CM/38/21/PL

The Arundel Gardener and Maidenhead Aquatics Crookthorn Lane Climping BN17 5SN

Retention of timber cladding to side (west) & rear (south) of mail building, lychgate to west of main building, timber cladding to generator housing & laying block paving and concrete slabs / replacement concrete slabs. Laying new shingle to existing made ground. This site may affect a listed building & is in CIL Zone 5 (Zero Rated) as other development.

*As-Existing Site Plan
with Proposals*

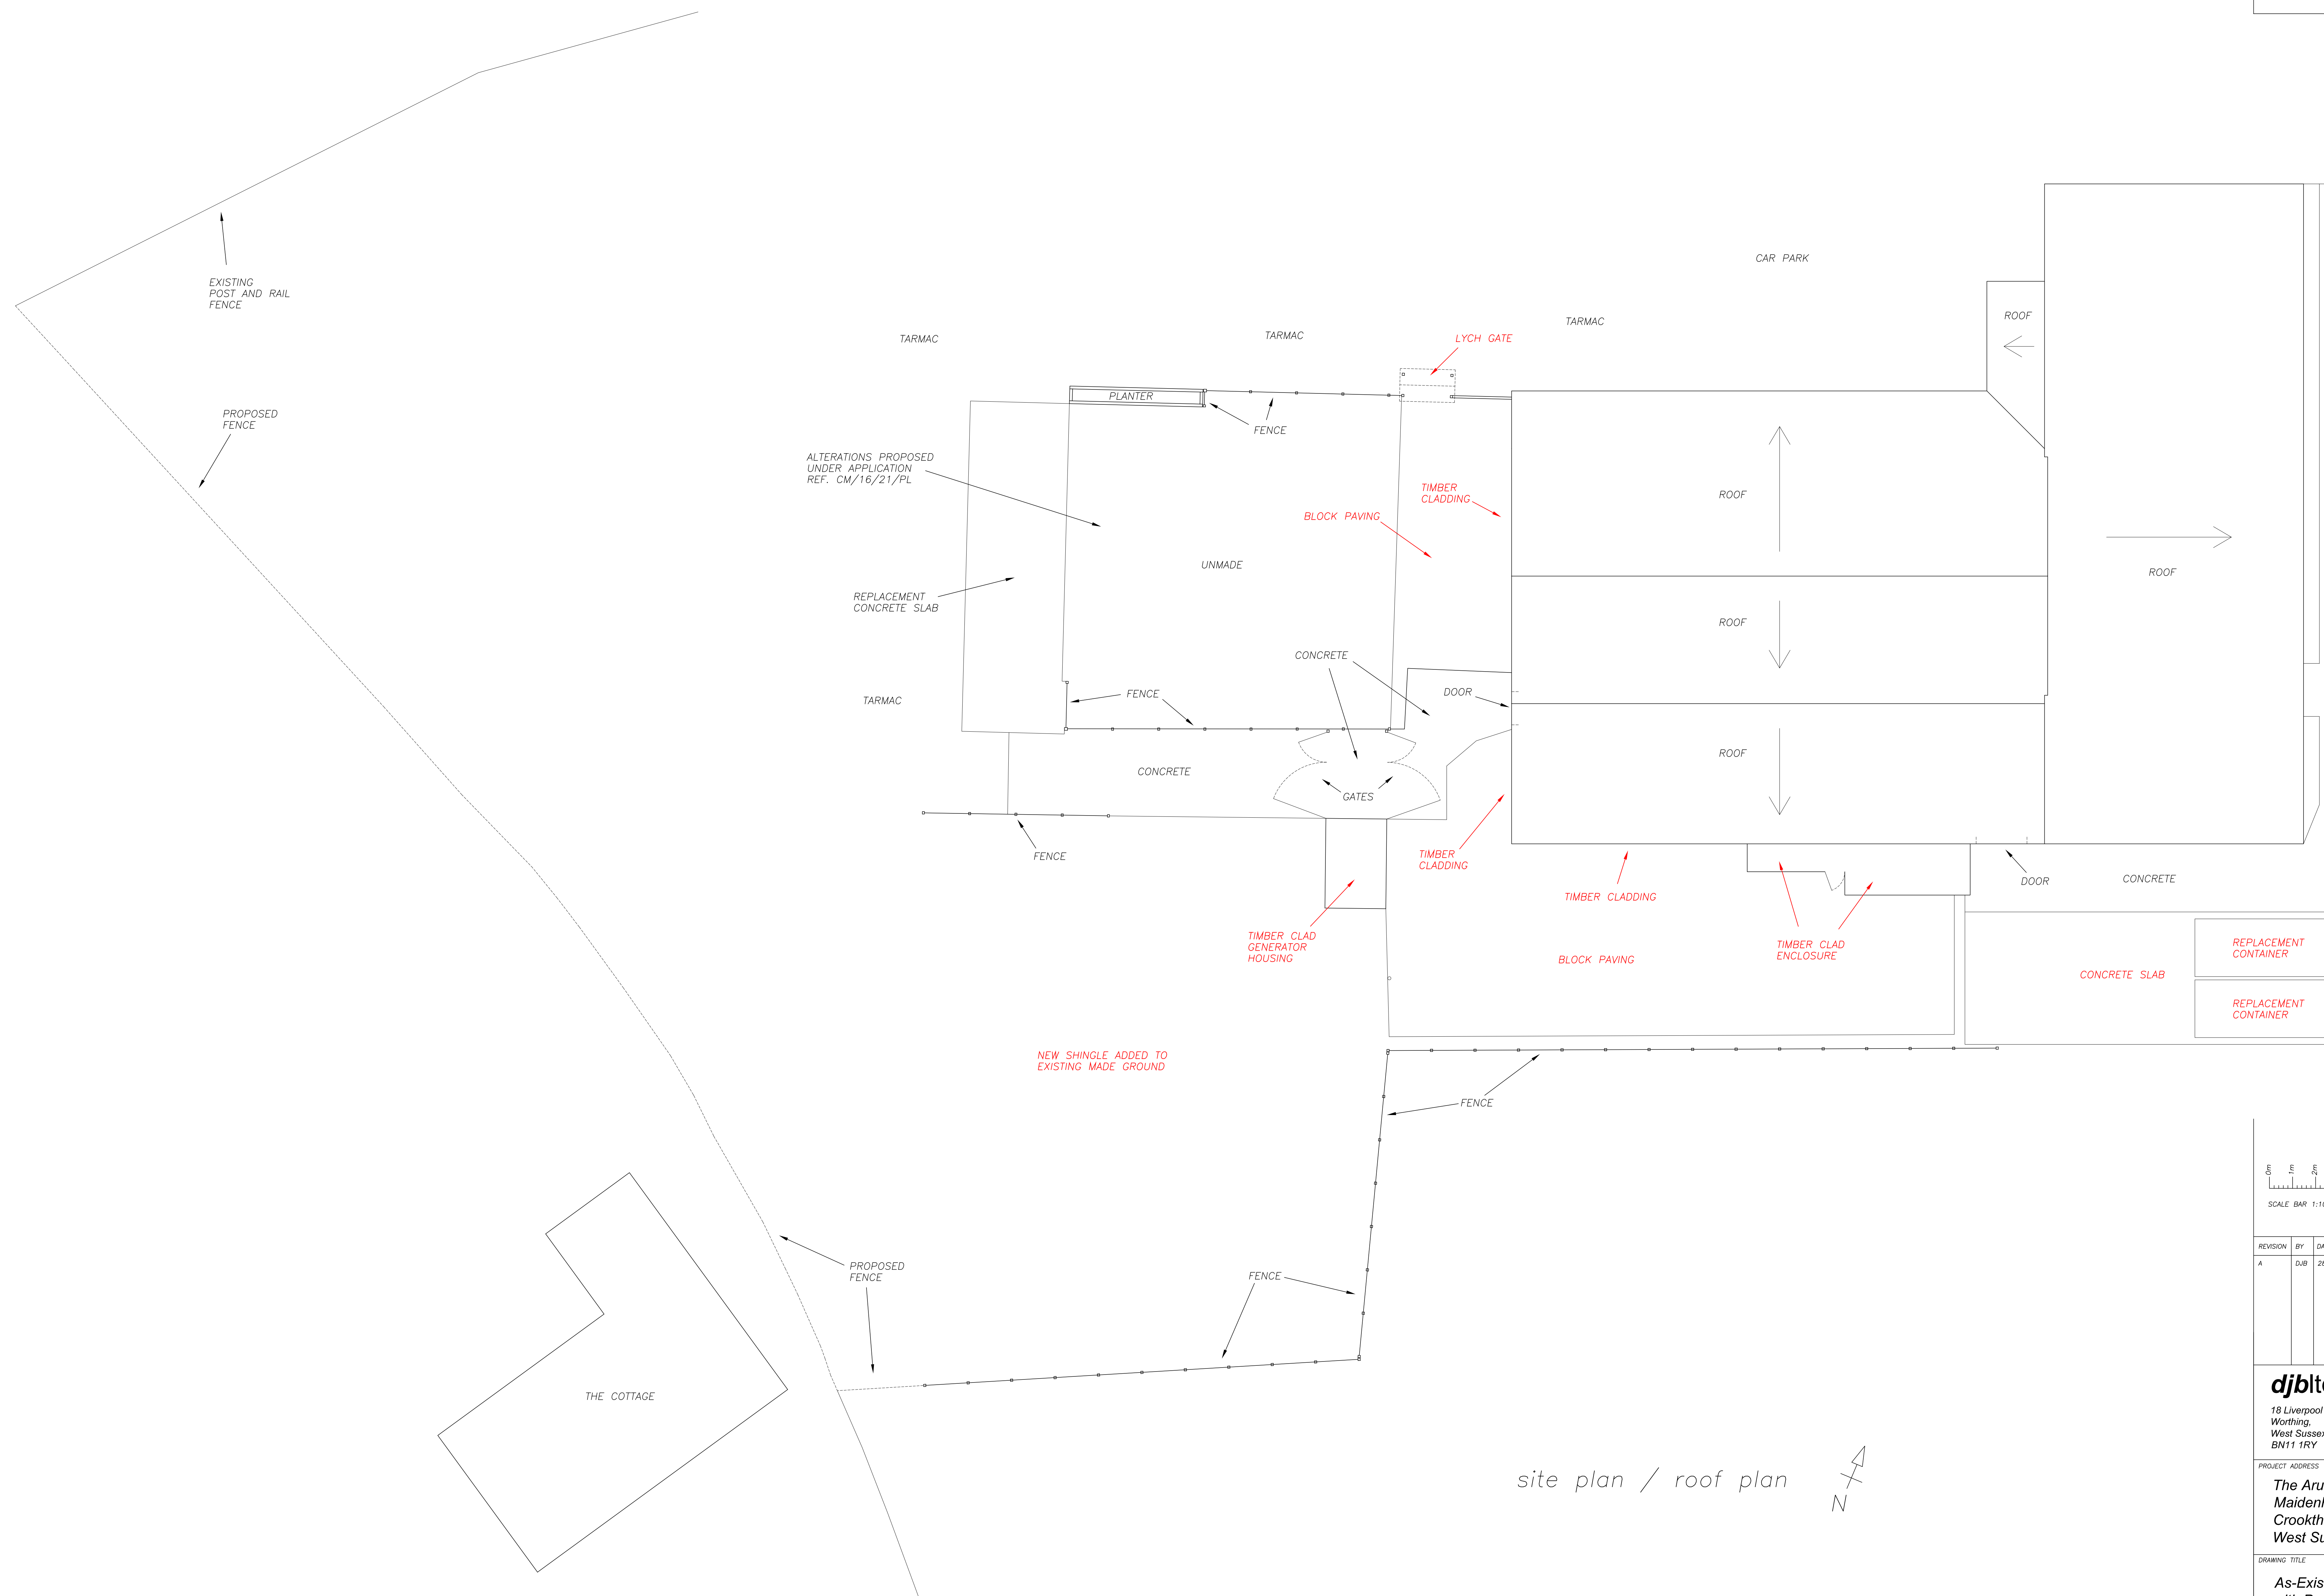
A review of the site plan also shows that the intention is for new fencing to be located on the boundary with the listed building. However, this is not included in the application description. Please can this be confirmed if this is to be included or not. This element is closest to the listed building and would have an impact upon it. If it is to be included, I would like to understand what it is to look like, its height, materials and how it is to be treated. It would also help to understand if the fencing is to have some form of landscaping in order to help soften its impact.

It would also help to some reinstate and improve the vegetative screening in that part of the car park closest to the listed building, so as to ensure that it would not be seen on the context of the proposed development.

**As-Existing Elevations
with Proposals**

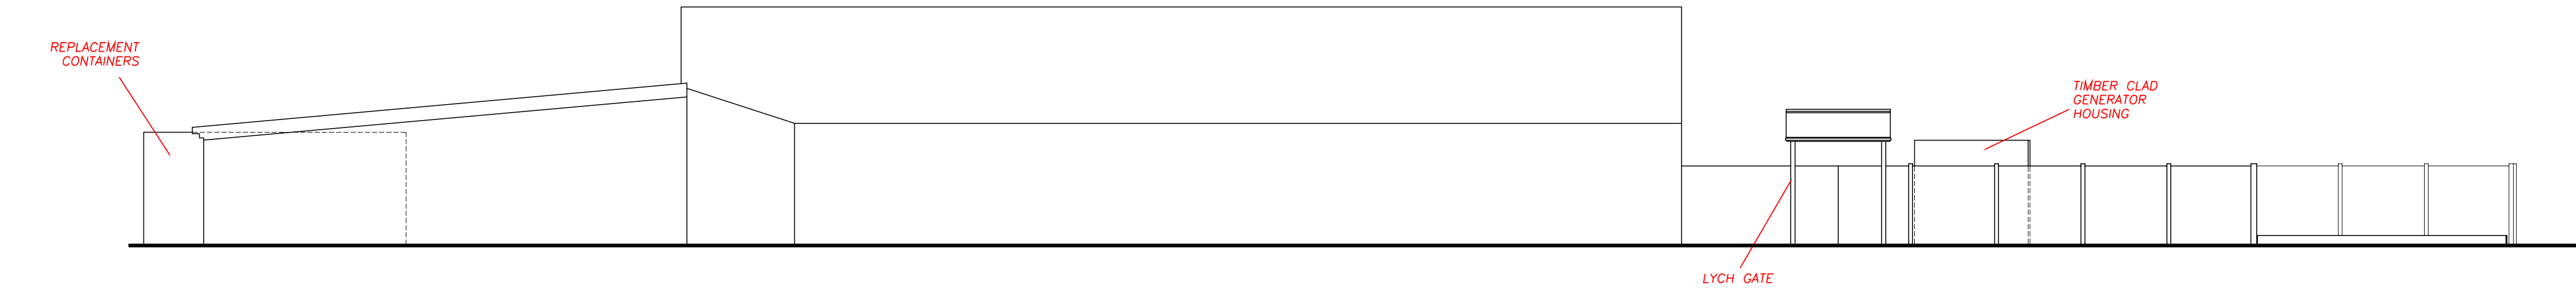
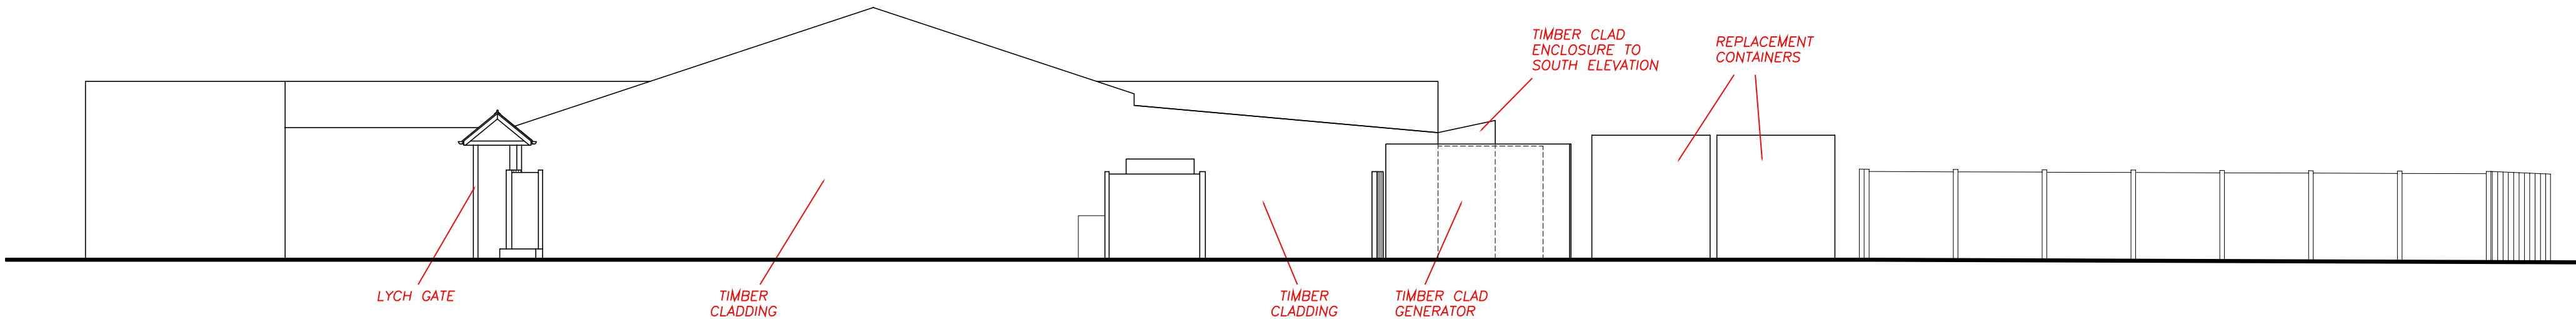
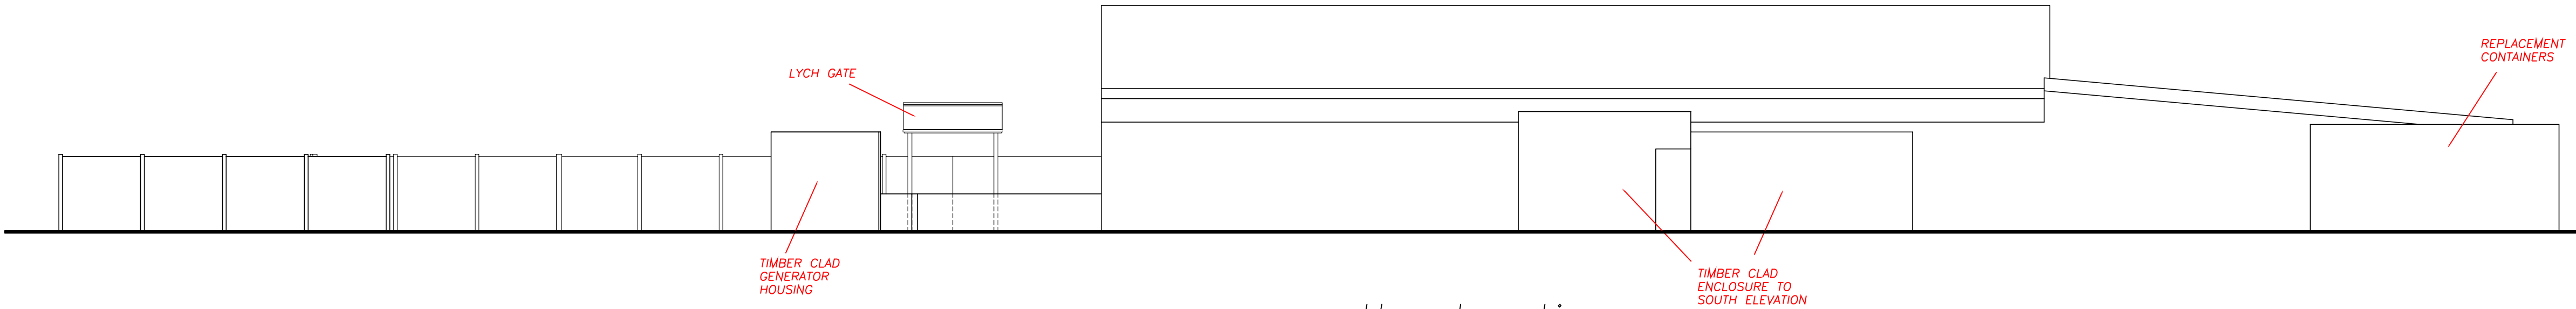
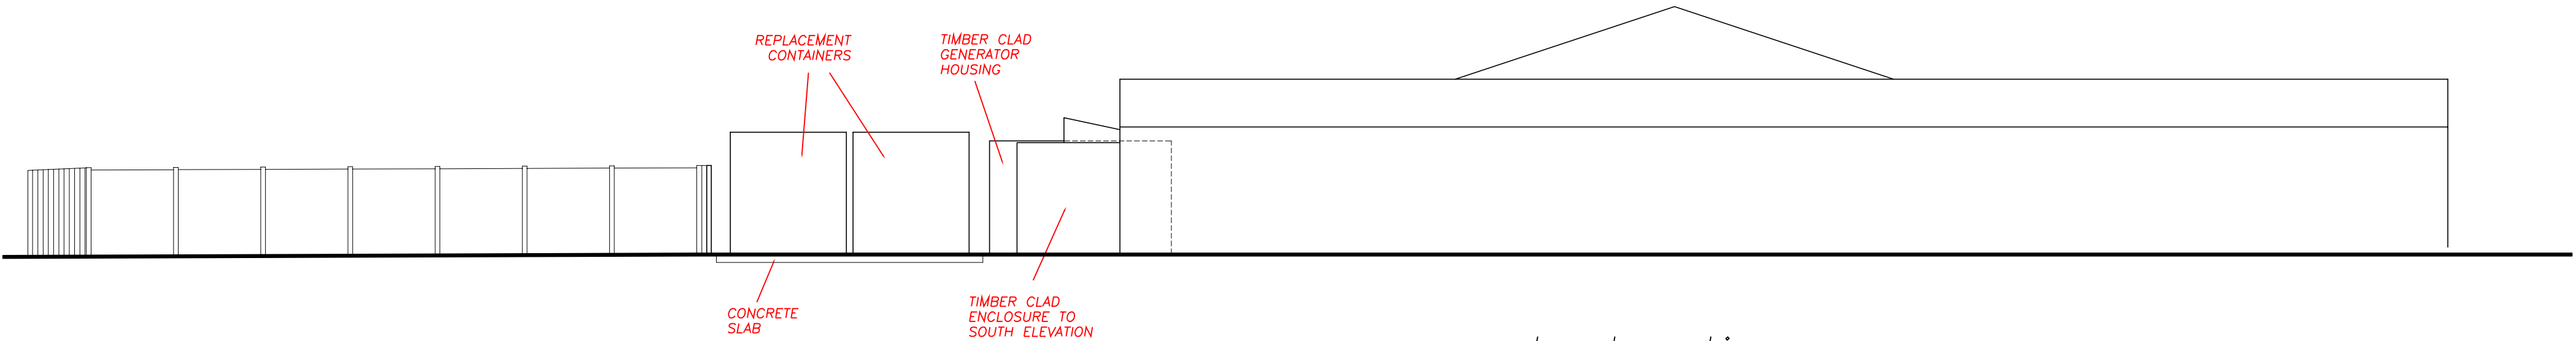
The plans indicate that it is only the western and southern elevations which are to be clad in the timber. This timber cladding appears to be an improvement upon the previous metal sheeting and is therefore acceptable.
